From: Simon Davis
Sent: 22 January 2025 15:59
To: Helen Murch [REDACTED]
Cc: Luke Vallins [REDACTED] Peter Cleveland
Subject: RE: P/114/24/RES - Draft agenda for meeting with Bargate tomorrow

The following is a summary of my issues with the application:

Project Land West of Pagham Road
Drawing House Type K1 - 2 Block
Elevations
Client Bargate Homes
Job no. BARG230419
Dwg no. HT.K1(2blk).e
Author CJB Checker
Status PLANNING
Client ref.

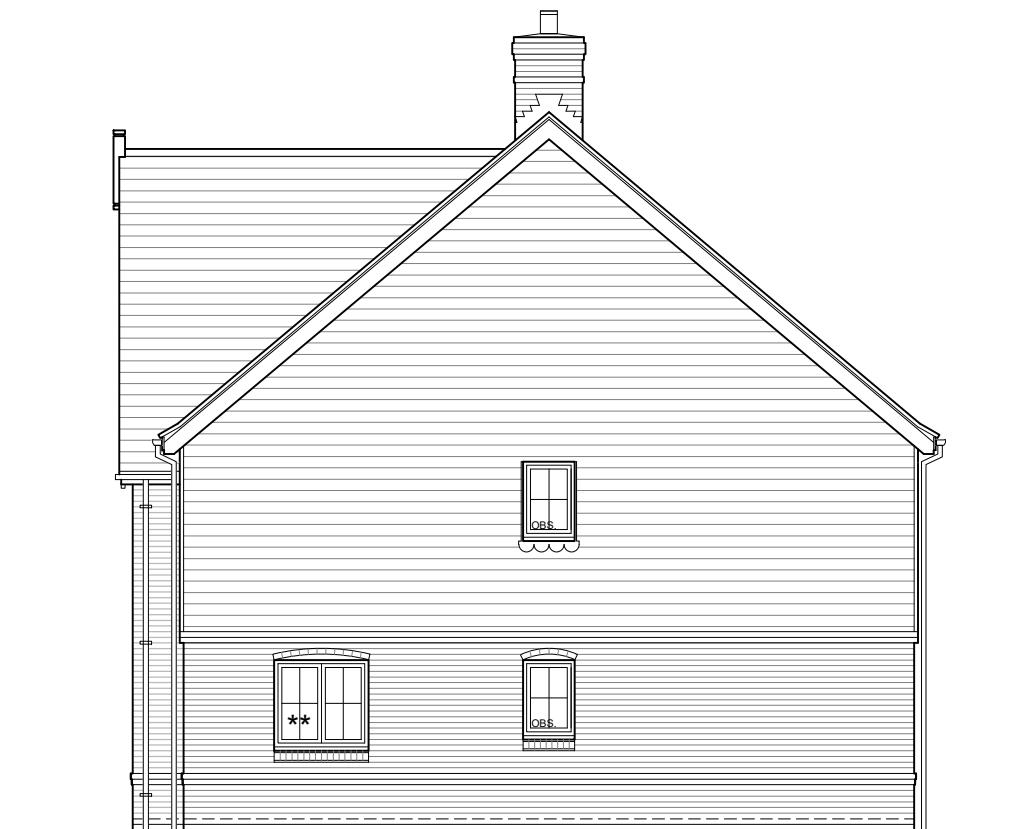
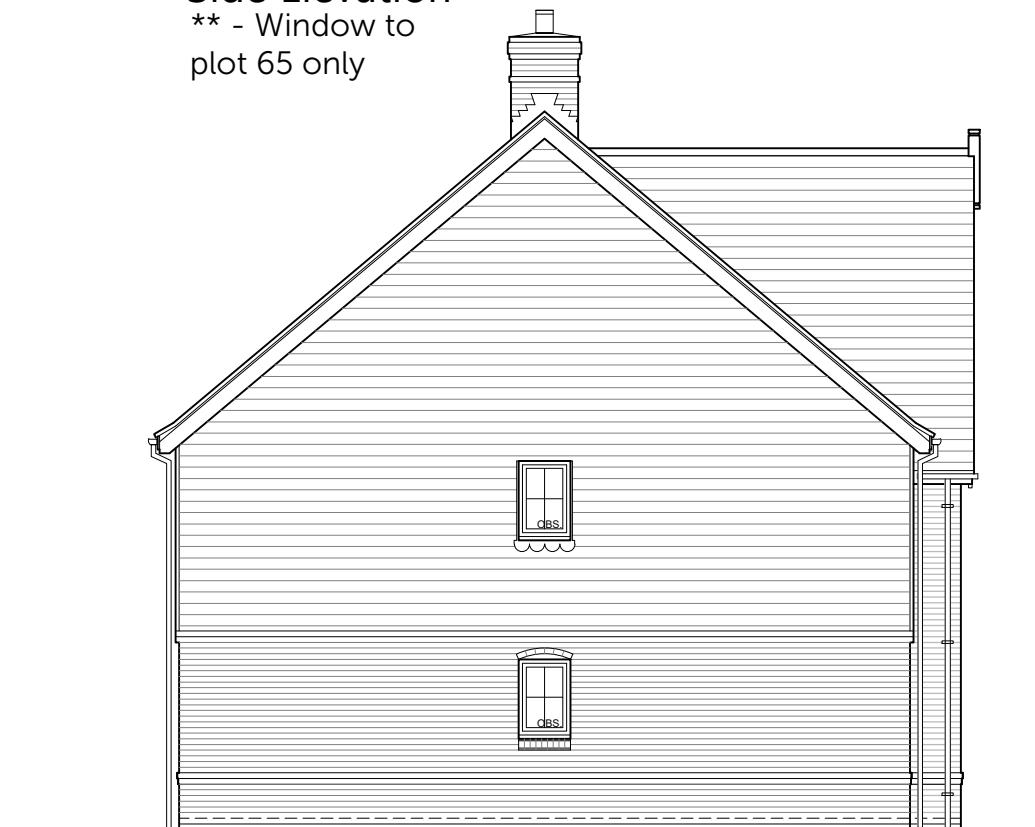
- Rear of plot 29 (rear FF bath/bed windows) to rear of 33/34 (FF landing window) is 13m (21m) – will be ok provided 34's landing window is O/G.
- Rear of plots 33/34 (FF landing window) to rear of 30 (2 FF bed windows) is only 12.3m (21m) – will be ok provided 34's landing window is O/G.
- Rear of plot 35 FOG (has an FF bathroom window) to rear of 26/27 (2 FF bed windows) is only 12.1-13.1m (21m) – will be ok provided 35's bathroom window is O/G.
- Rear of plots 36/37 (has FF rear landing window) to rear of 25 (FF 2 x bed, 1 bath windows) is only 16-16.6m (21m) – will be ok provided 37's landing window is O/G.

Project Land West of Pagham Road
Drawing House Type 2x1M Elevations

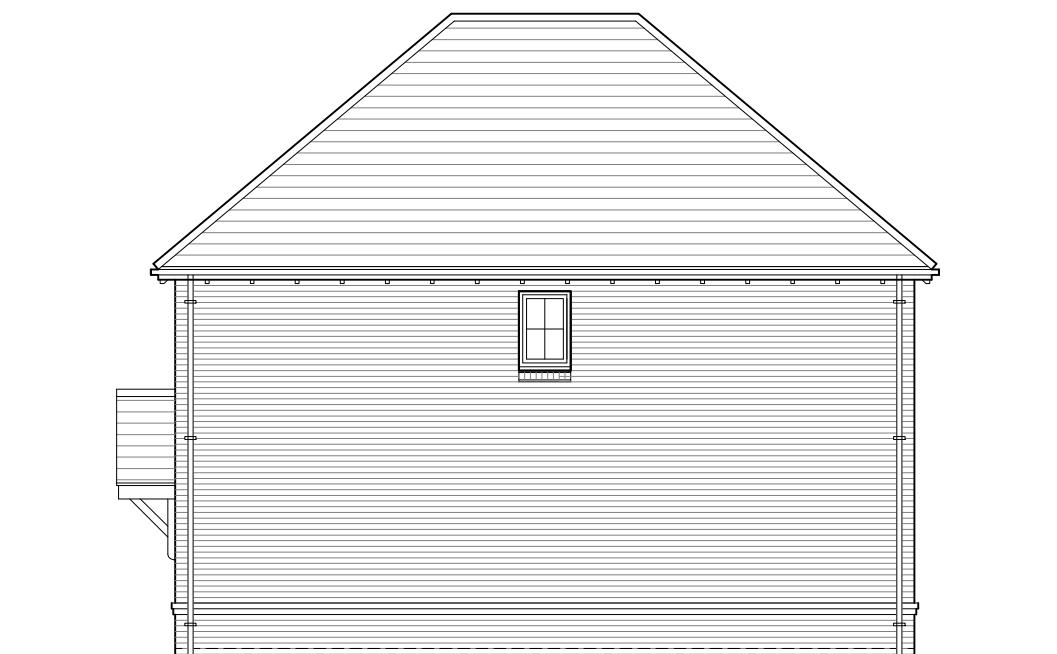
- Southern elevation of plots 36/37 (FF bed, bath, kitchen windows) to rear of 22 Mill View Close is only 13.8m (ADG requires 16/21m – nb the ADG does not specify a front-to-rear specific distance).
- Front of plots 33/34 (FF bed, bath, kitchen windows) to the rear of 7 Old Barn Close is 15.7m or 12.6m to its conservatory (16-21m).
- Rear of plots 14/15 (2 x FF bed windows) to rear of 8 Mill View Close is 16-17.2m (14.5m to edge of conservatory) (21m).
